10 November 2011

**RE: MP 10_0027 – Stages 2 & 3, 1 Australia Avenue Sydney Olympic Park
Response to SOPA letter**

SOPA wrote to the Department of Planning & Infrastructure on 17 October 2011 raising additional issues in response to the Preferred Project Report. Each of the issues raised by SOPA are addressed below.

Scale 1:200@A1, 1:400@A3
Drawn _____
Project No. S11202
Status DA
Plot Date 22/9/2011 9:03:36 AM
Plot File S:\11200-11202\11202_batberg_homesite-00_ealcad.plt
Drawing No. DA02.222[A] (Revisor)

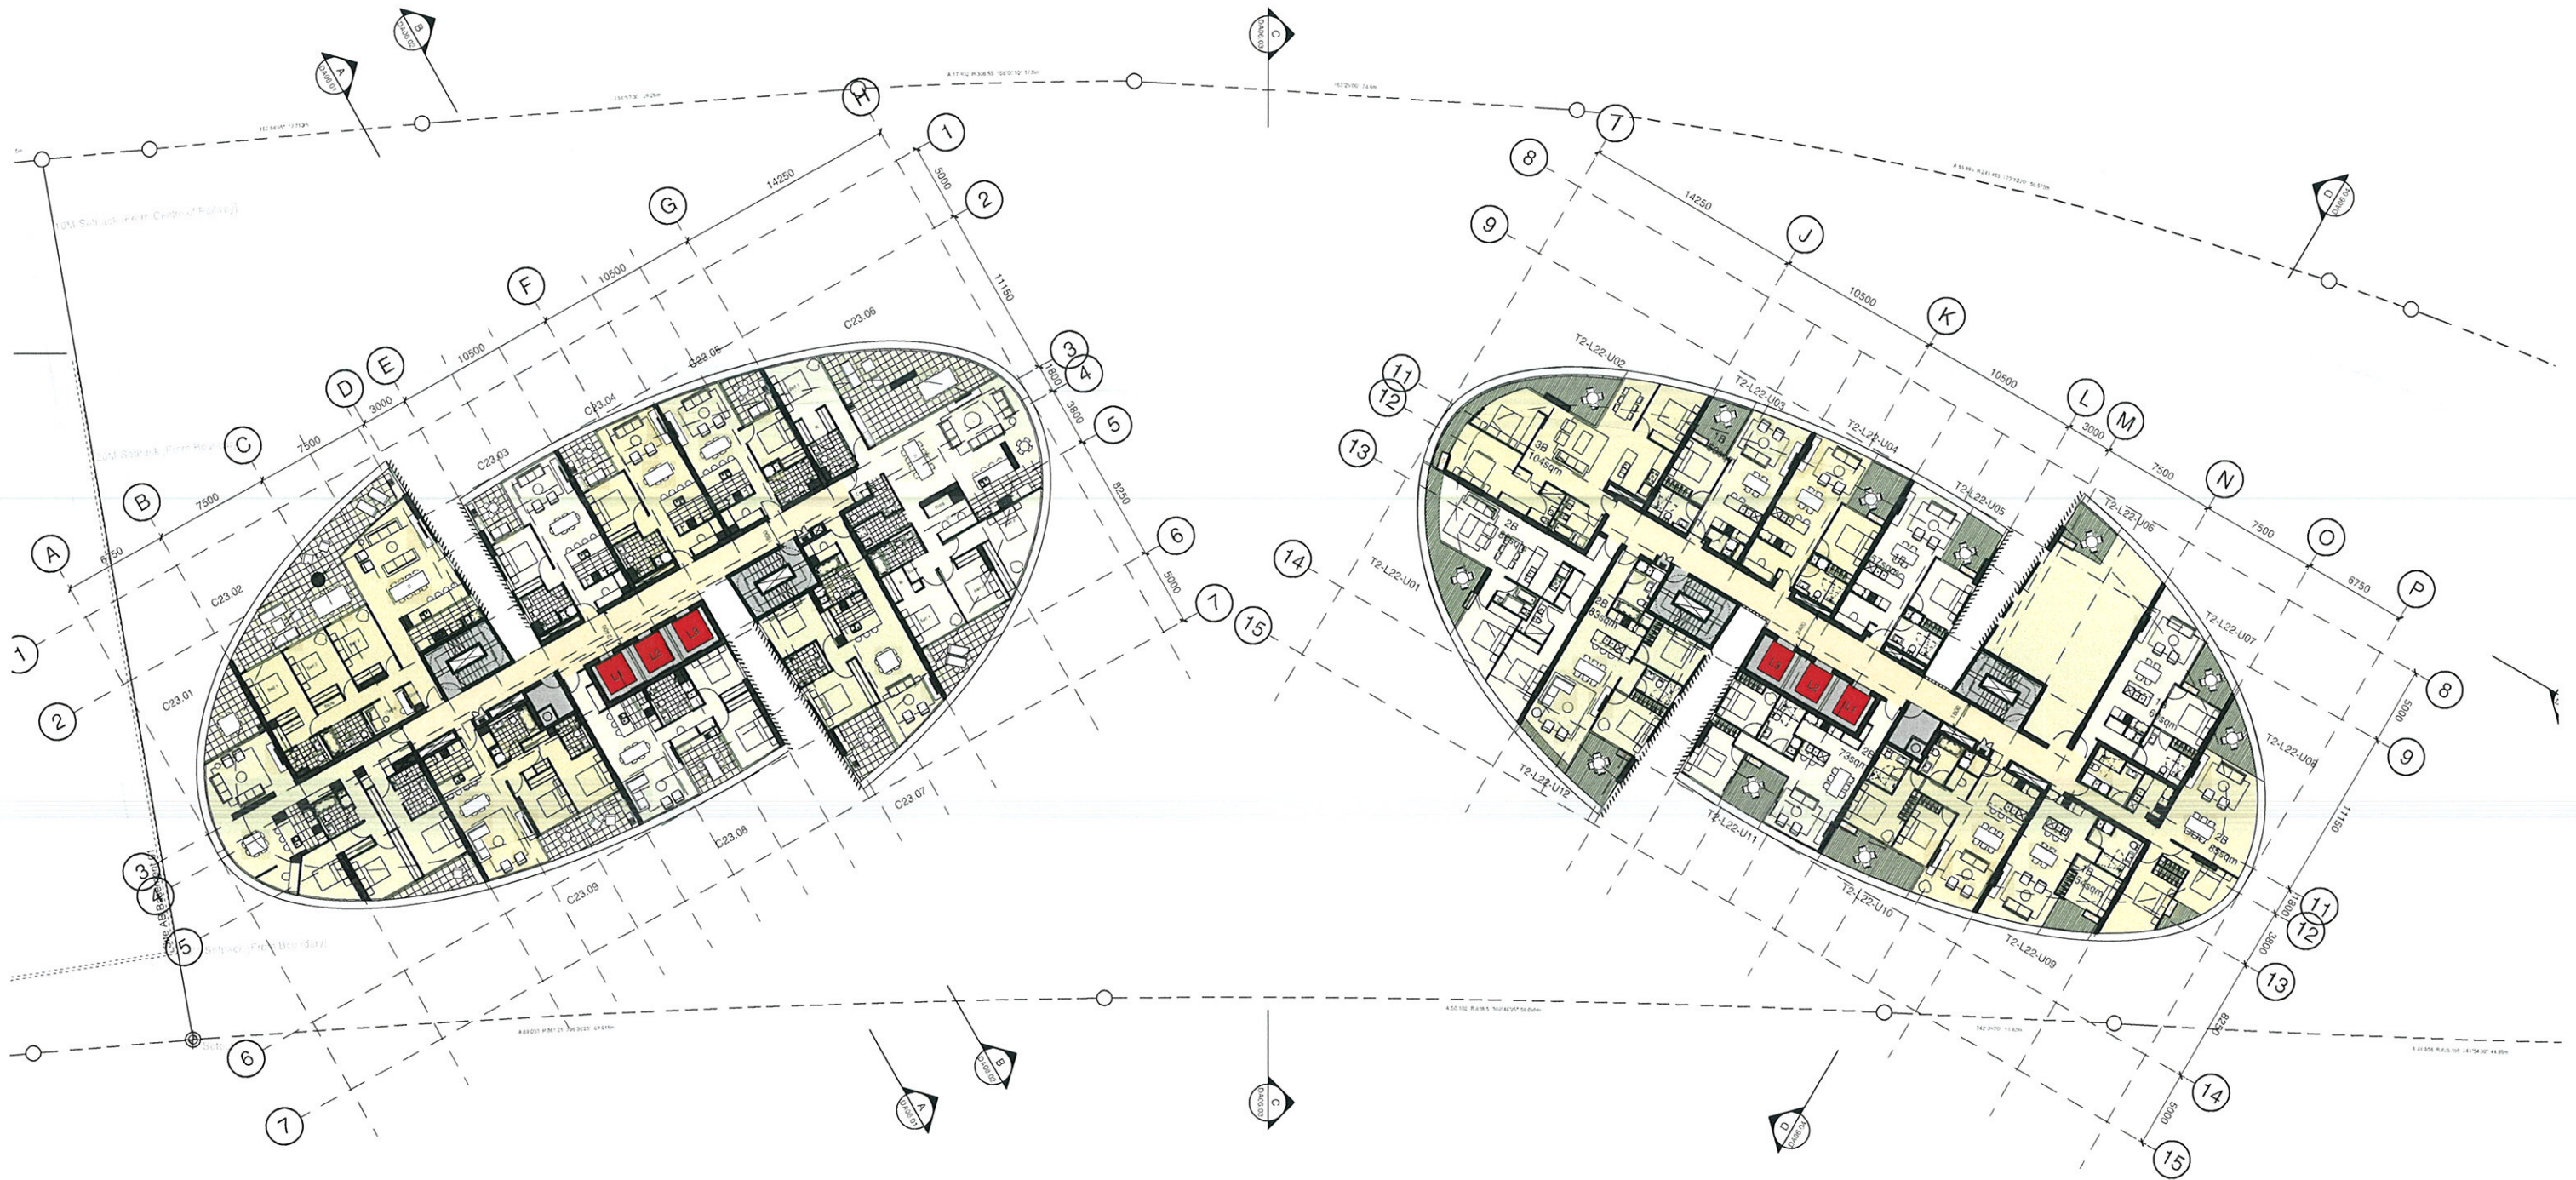
1.13 Anomalies – Drawing No. DA 02.222(A)

Details of unit 6 on Level 22 in Tower 2 have been provided.

DA02.200[D]

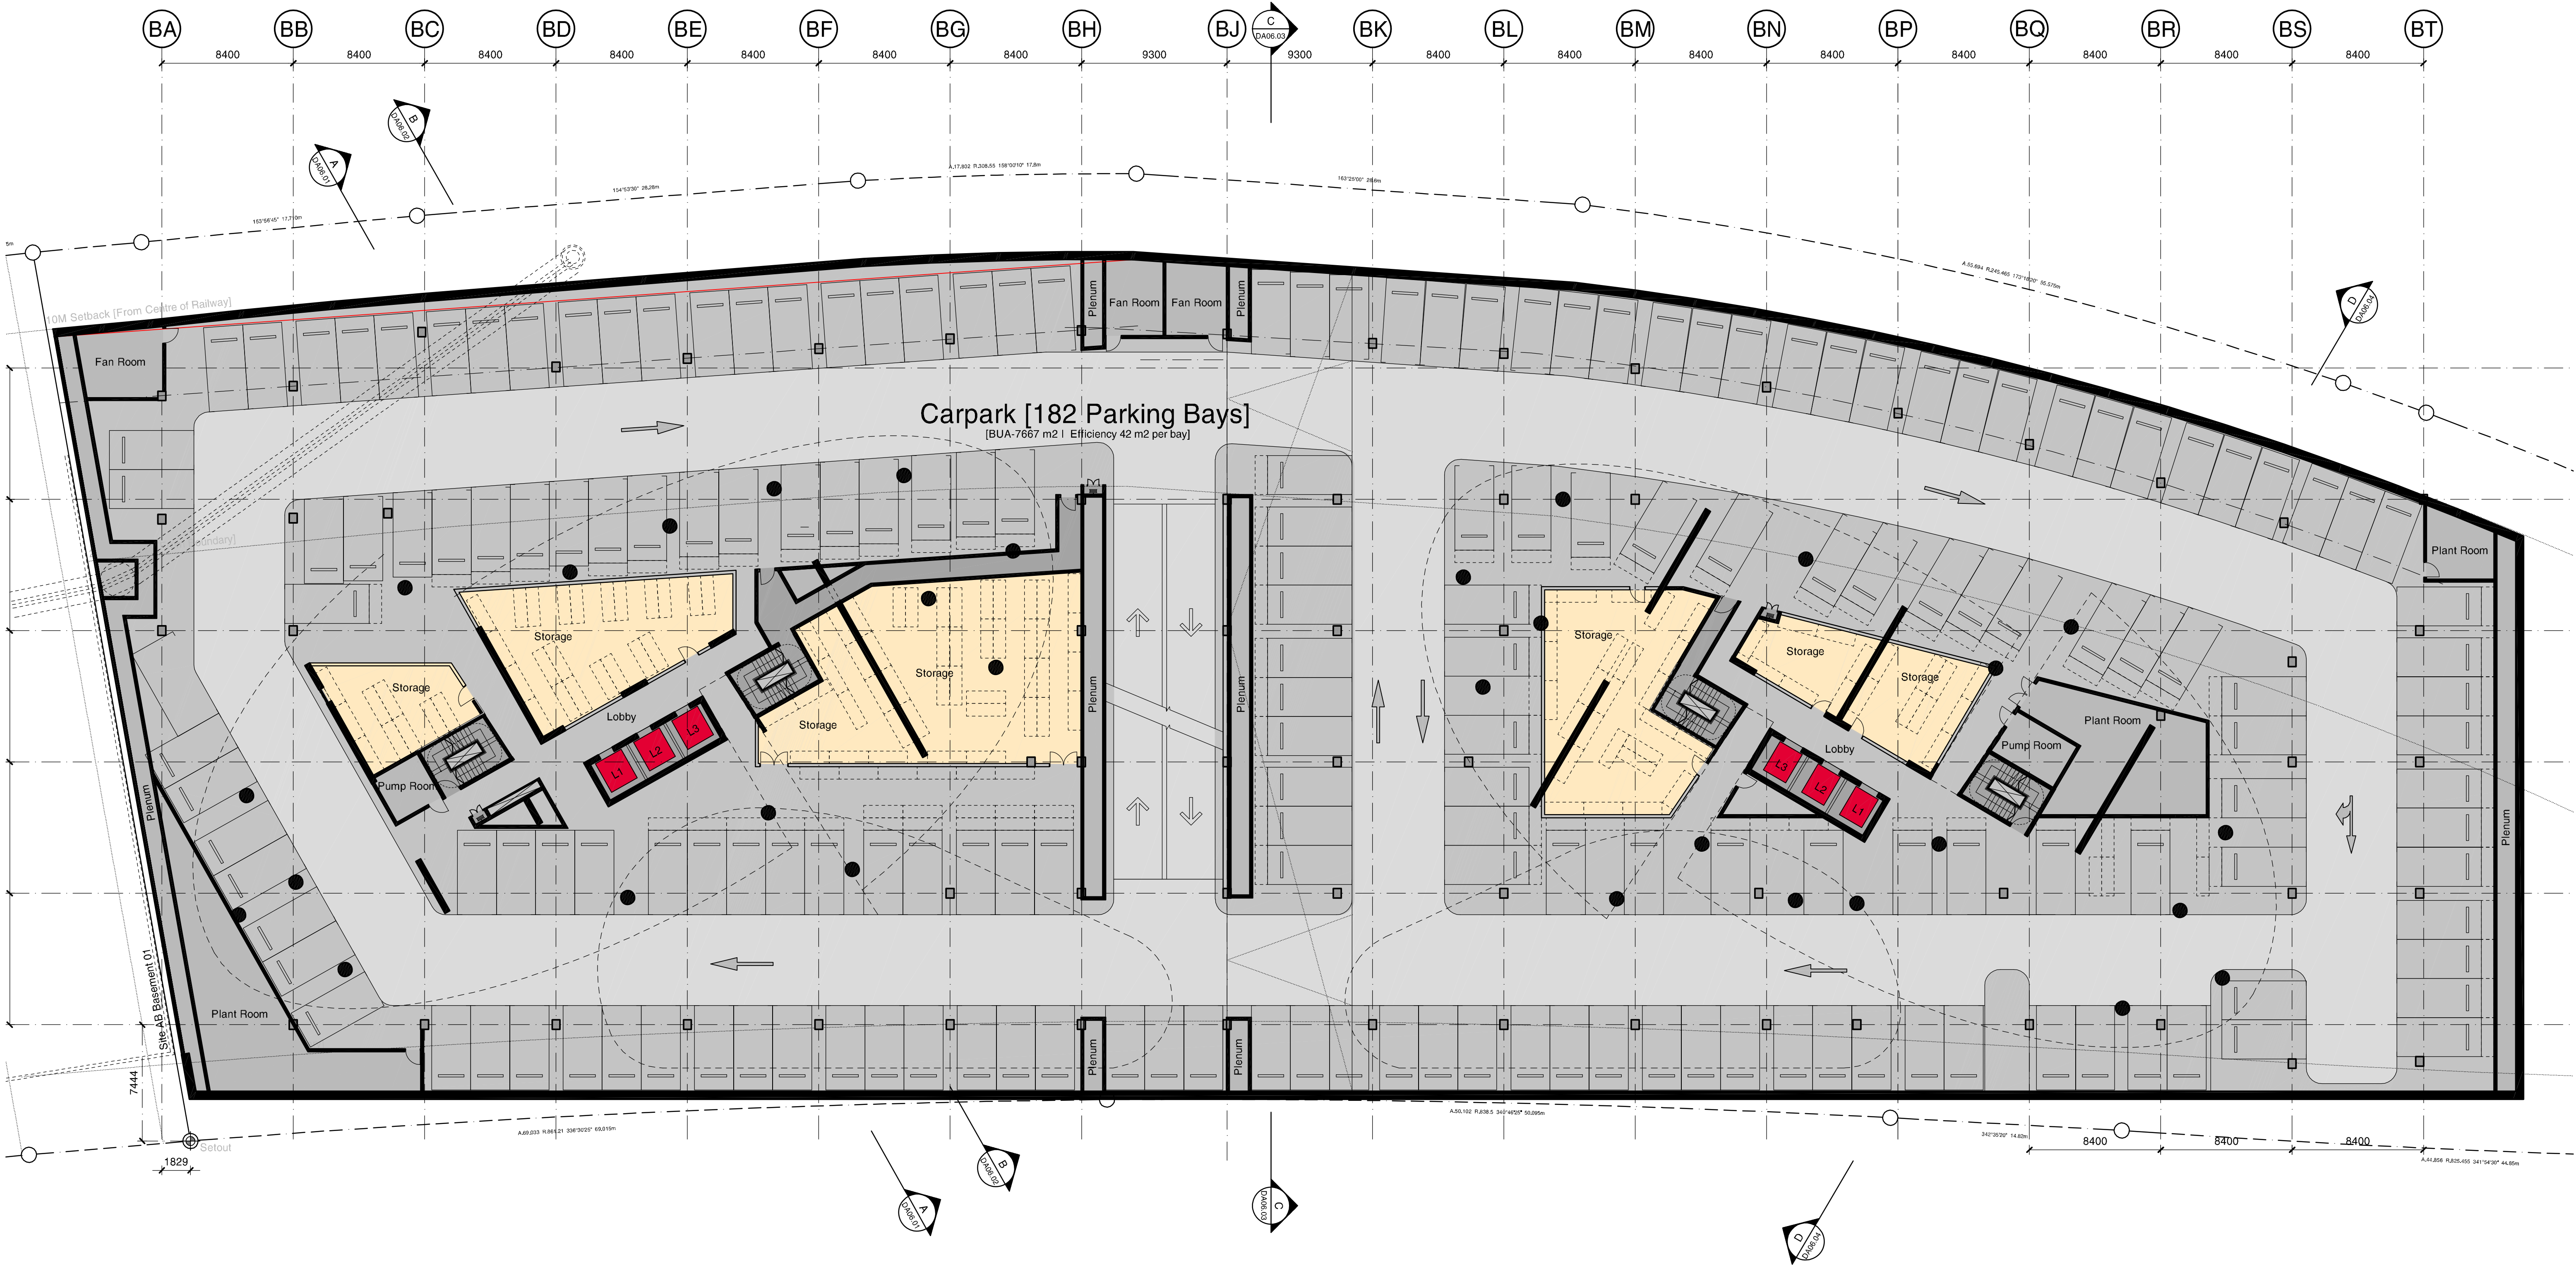
SOPA request that bicycle parking for residents and occupants should be provided within the upper parking levels. Bicycle parking has been relocated to the Ground Floor Level with direct access to the common lobbies which is more conveniently located for occupants, than proposed in the Environmental Assessment. Refer to Drawing No. DA02.200(D) submitted under separate cover.

1 West Elevation
1:250

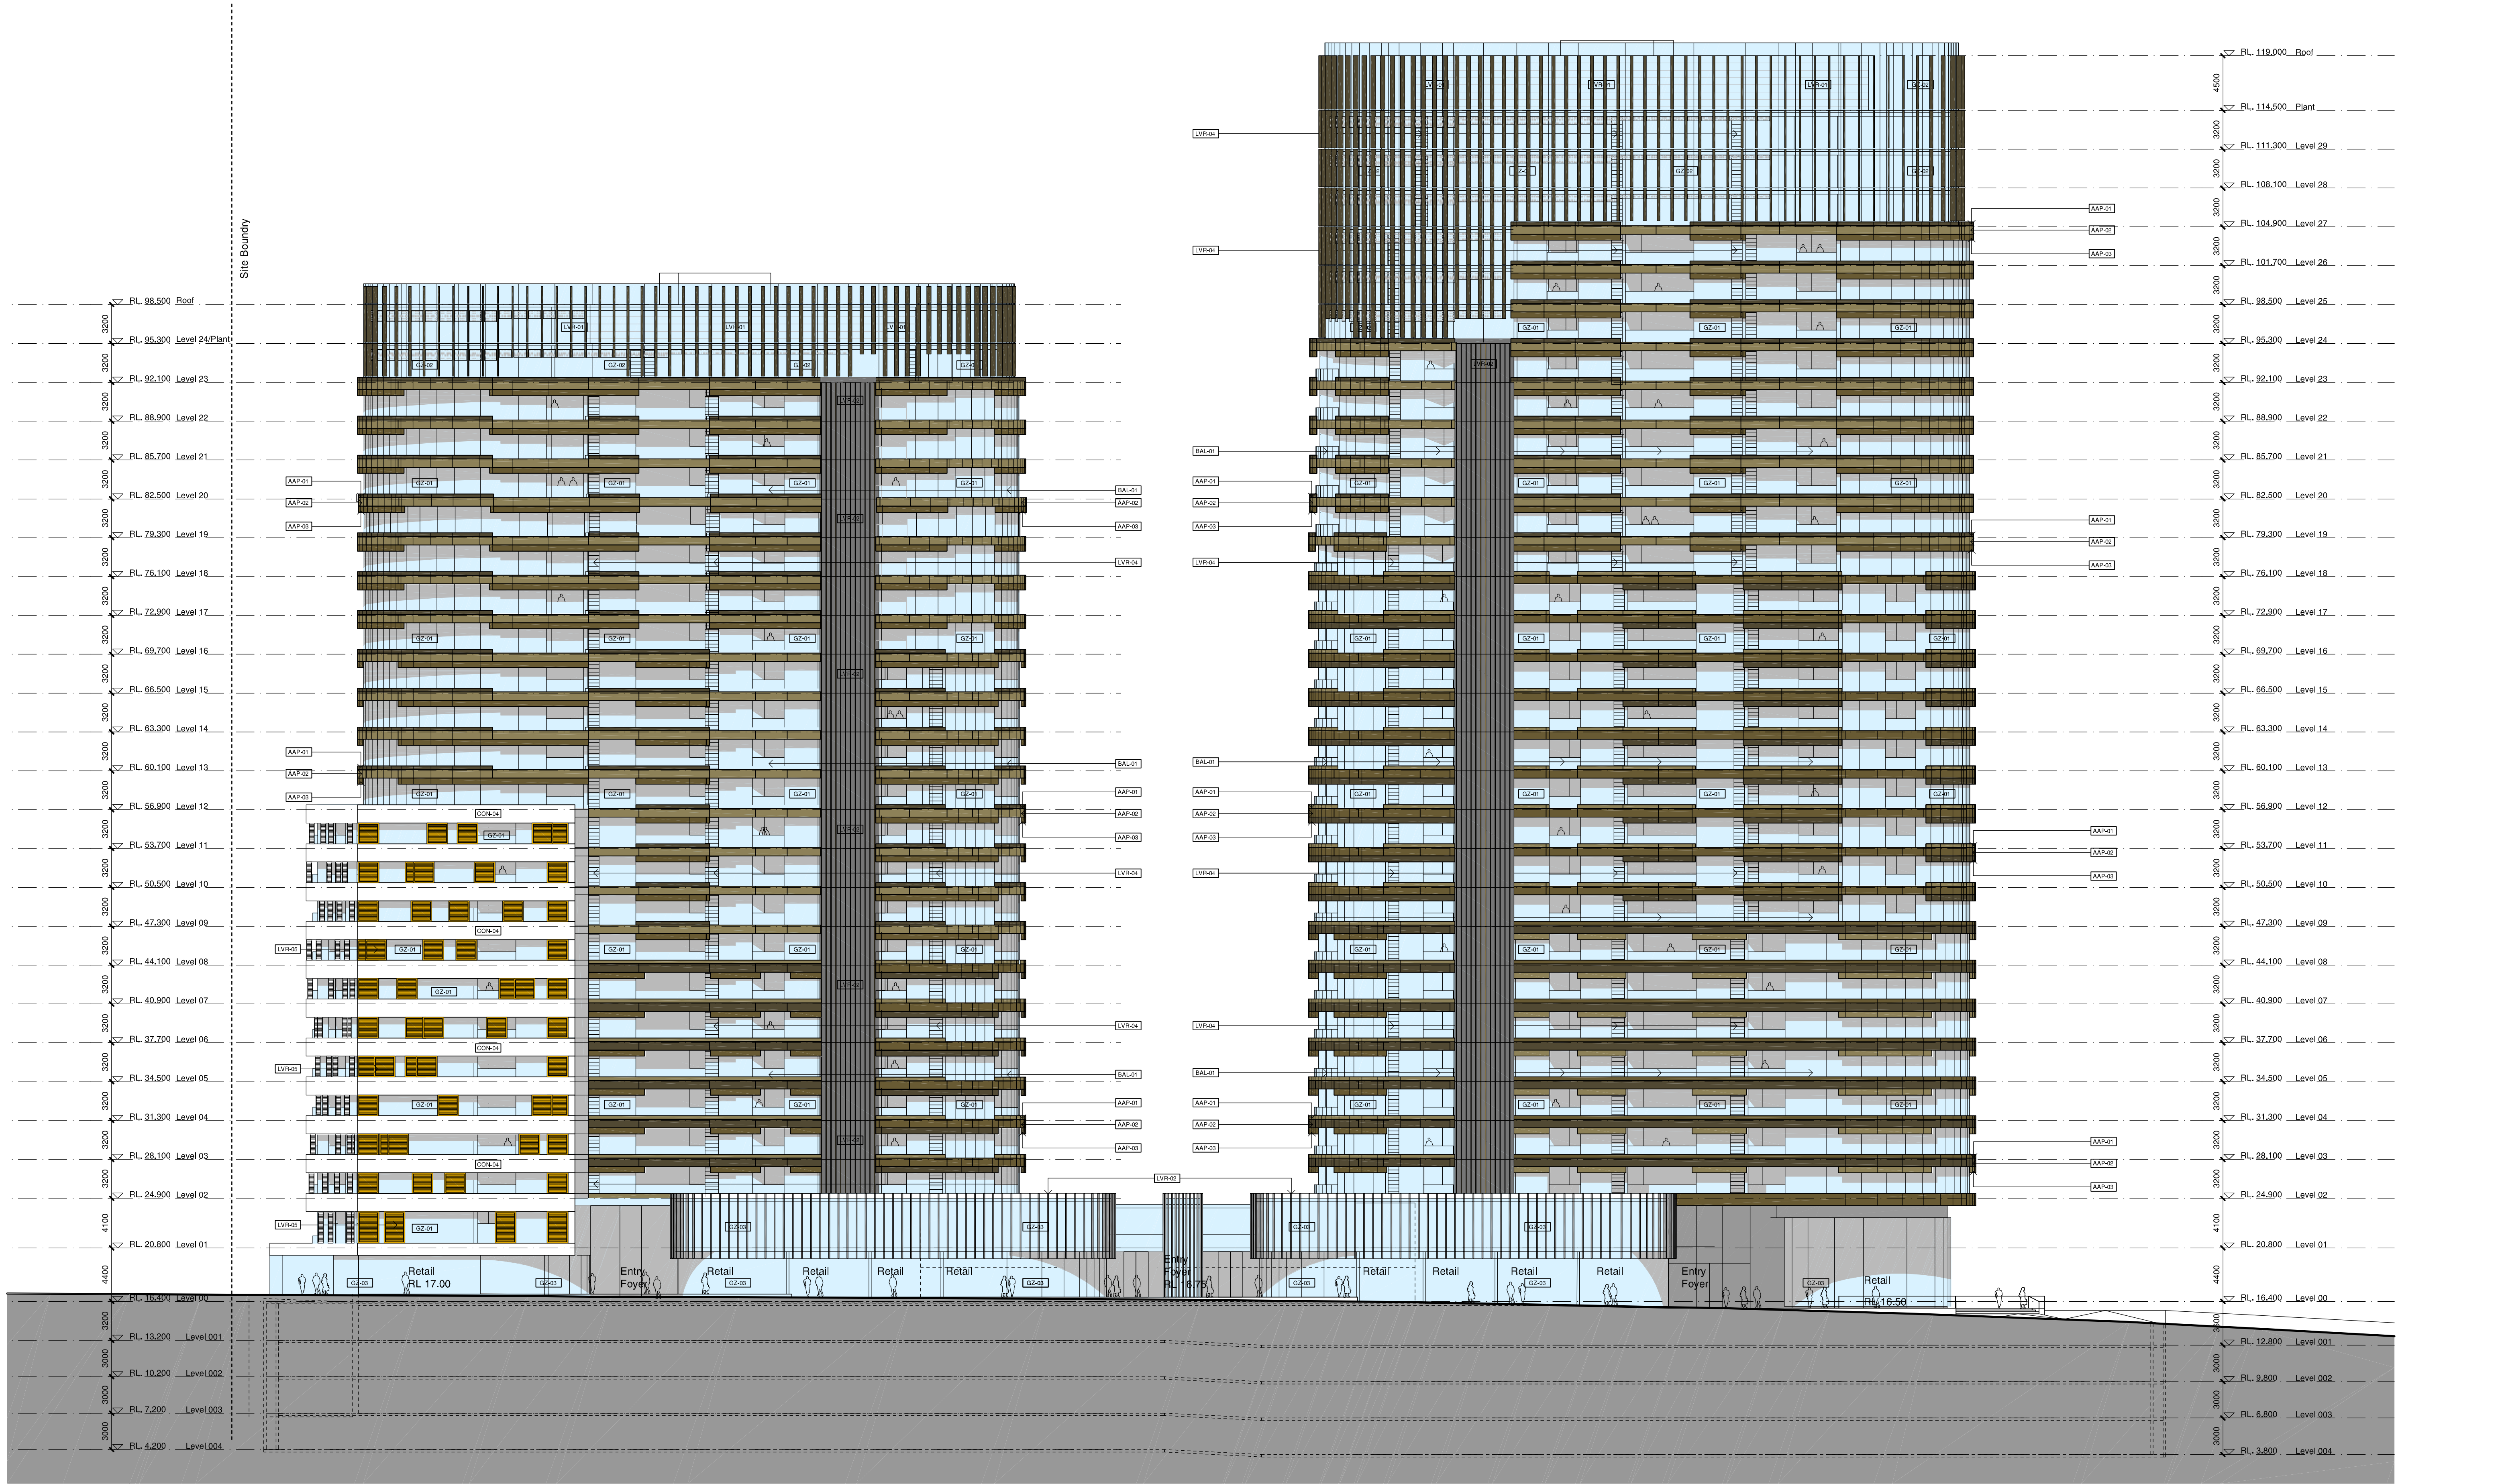
1.11 Anomalies – Drawing No. DA 05.02(A) – West Elevation

Amendments to the Ground Floor retail tenancies have been made to the West Elevation.
